**From:** [Roger & Diana Smith](#)  
**To:** [\\_planningadvice](#)  
**Subject:** H14-1218-21 Yews Farm, Spalding Road, Pinchbeck OBJECTIONS  
**Date:** 19 December 2021 16:29:28  
**Attachments:** [21.12.19 H14-1218-21 objection.docx](#)

# **PEDALS 2021 - Spalding's Cycle Action Group**

## **OBJECTIONS to application H14-1218-21 : proposed residential development at Yews Farm, Spalding Road, Pinchbeck**

PROJECT:	Proposed Residential Development at Vernatt's Strategic Urban Extension Phase 1
DRAWING:	Boundary Treatment Parcel 1-Yews Farm 100 Plots
SCALE:	1:500@A1
DATE:	NOV.2021
DRAWING No:	74-BT-01
DRAWN:	MII
REVISION:	B

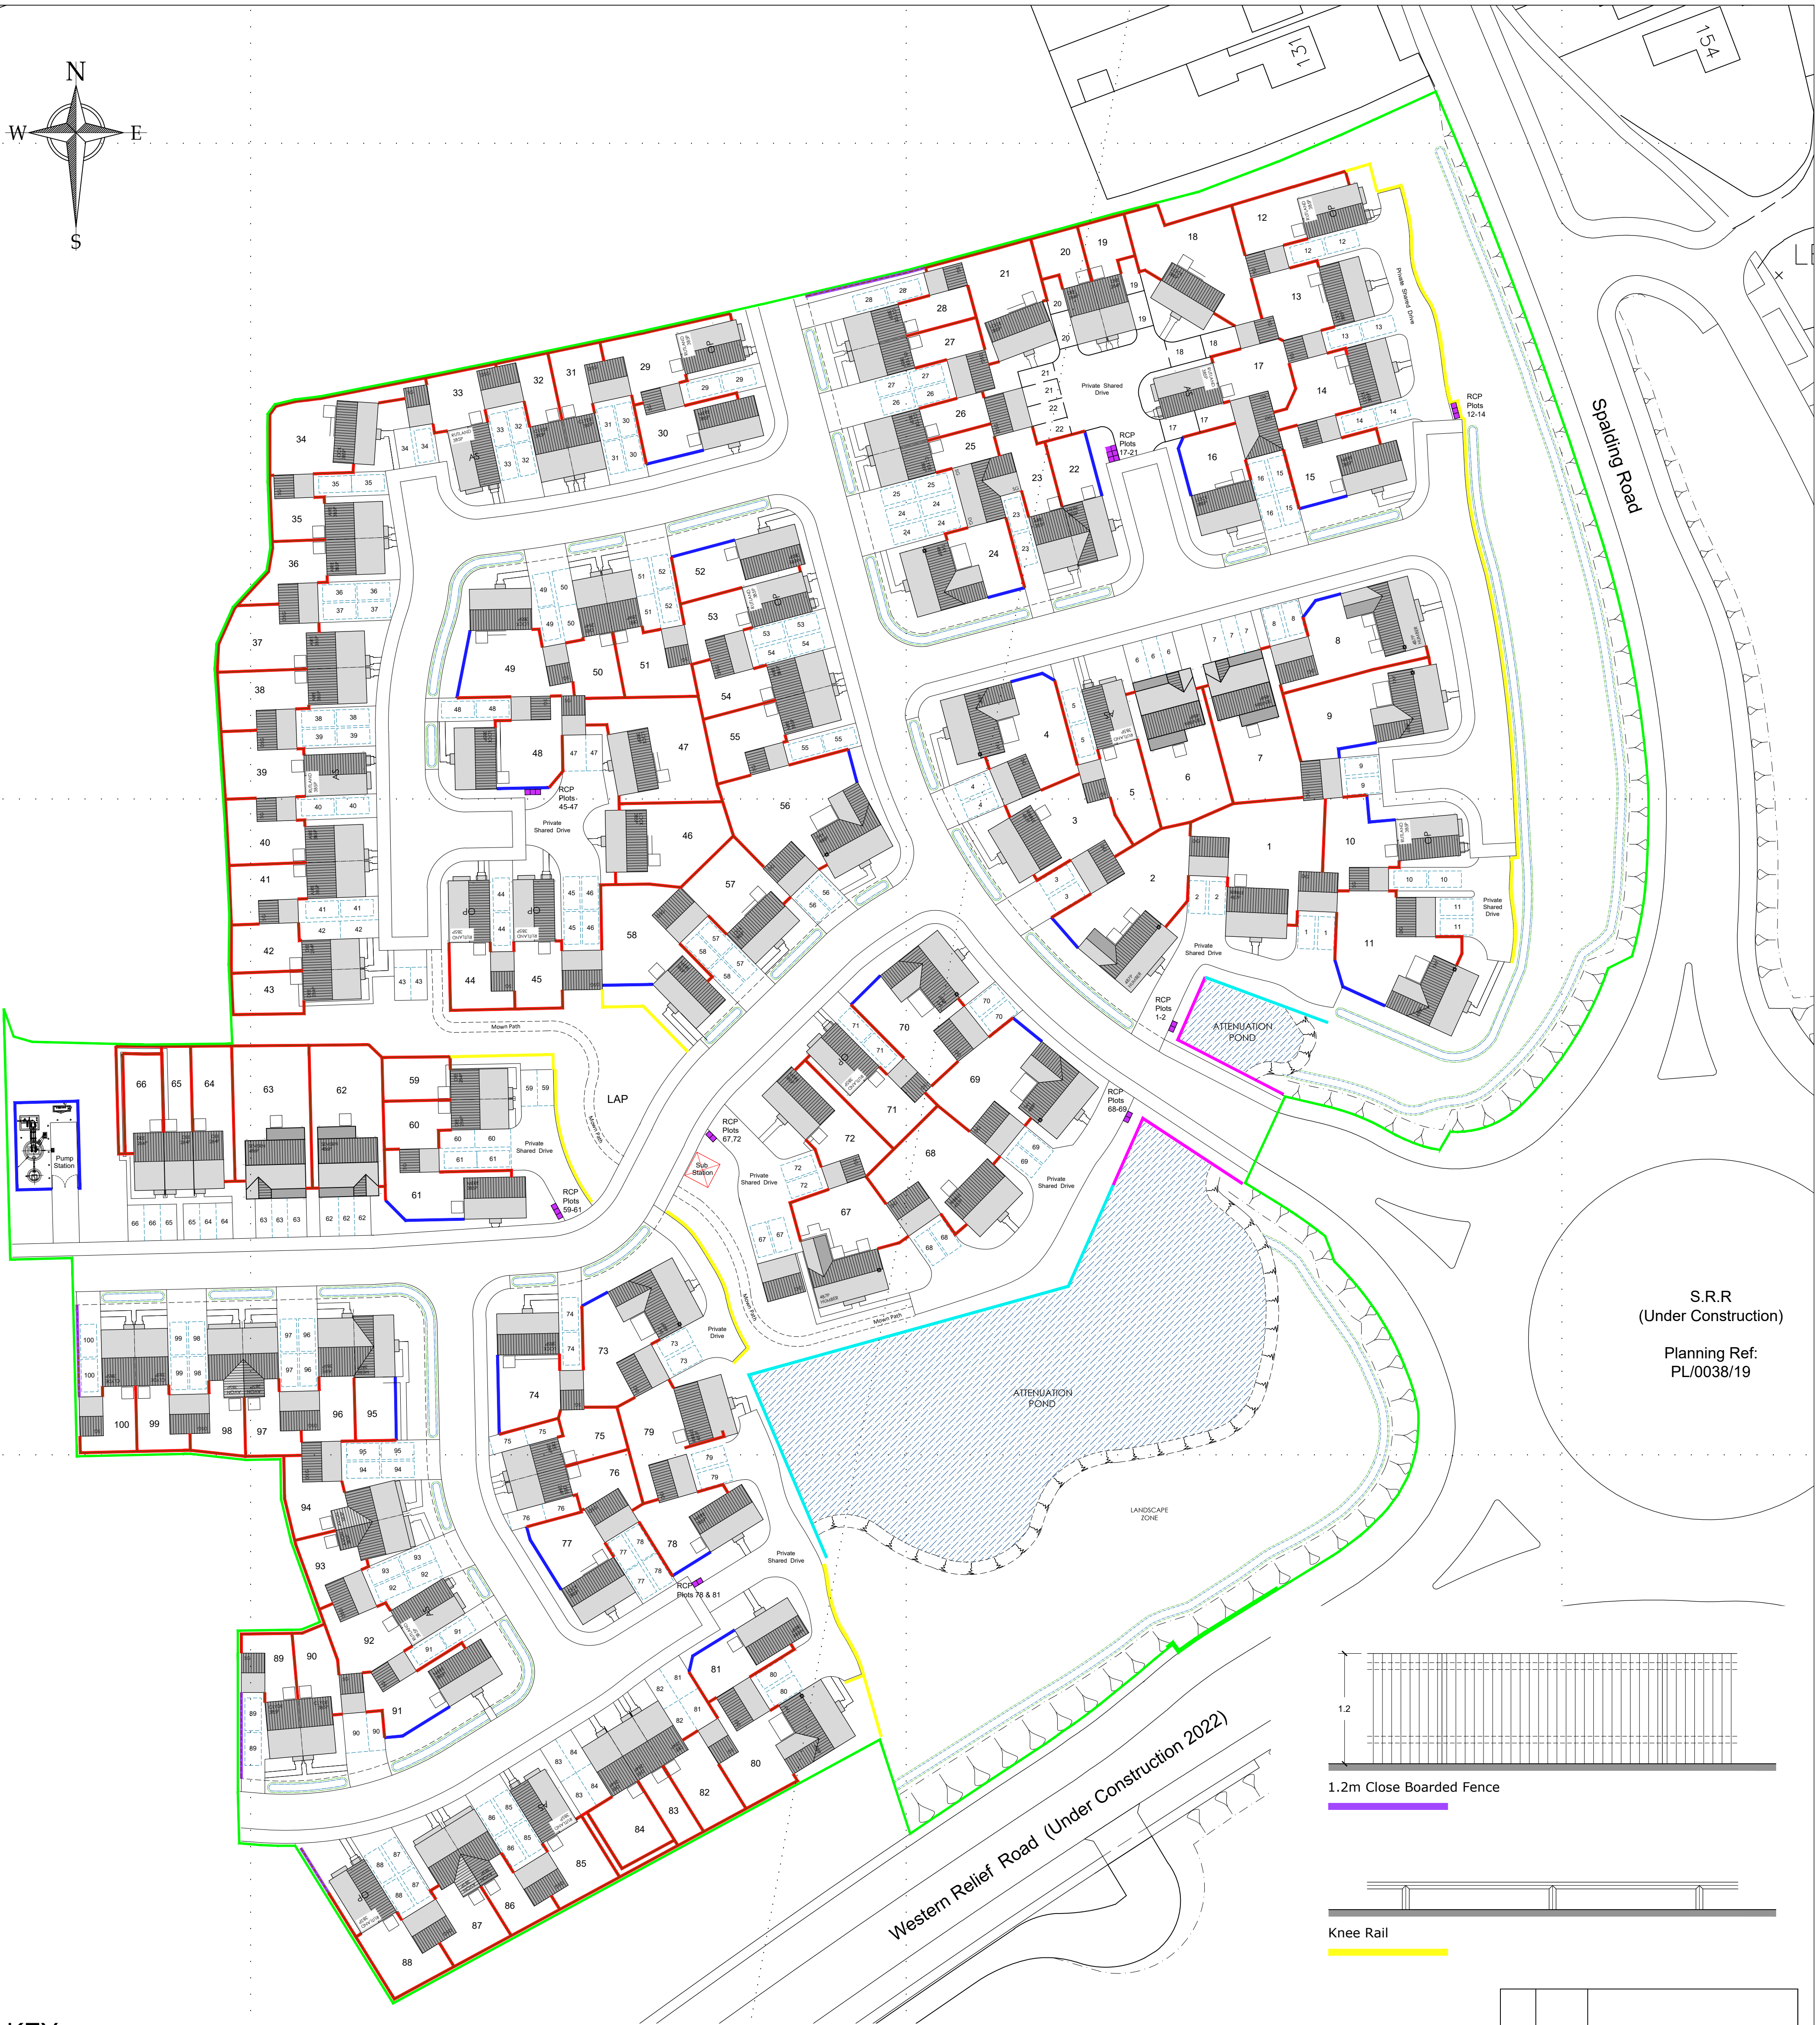
At the very least, the main routes through the estate shown in the full application, (i.e. the road leading to the western boundary which will also be the access to the land subject of the outline application, and the road leading to the northern boundary which will give access to further development land) should have dedicated provisions for cycling. These two roads will eventually serve a large number of homes, and the T junction where the two roads will meet should be redesigned to include safe provision for cycling.

Footpaths not alongside roads, for example those leading from the ends of culs-de-sac, should be dedicated for use by pedestrians and cyclists and should be of suitable width and construction for that purpose.

Policy 36 of the Local Plan, sets out clearly in paragraph 2c the requirements for cycle parking for major residential developments. However, question 10 of the application form and the details shown on the submitted plans make no reference to cycle parking. (In

i) that if planning permission is to be granted for the full application, this should not be done until the plans have been amended to include details of cycle parking for each dwelling in accordance with Policy 36 to the Council's satisfaction,
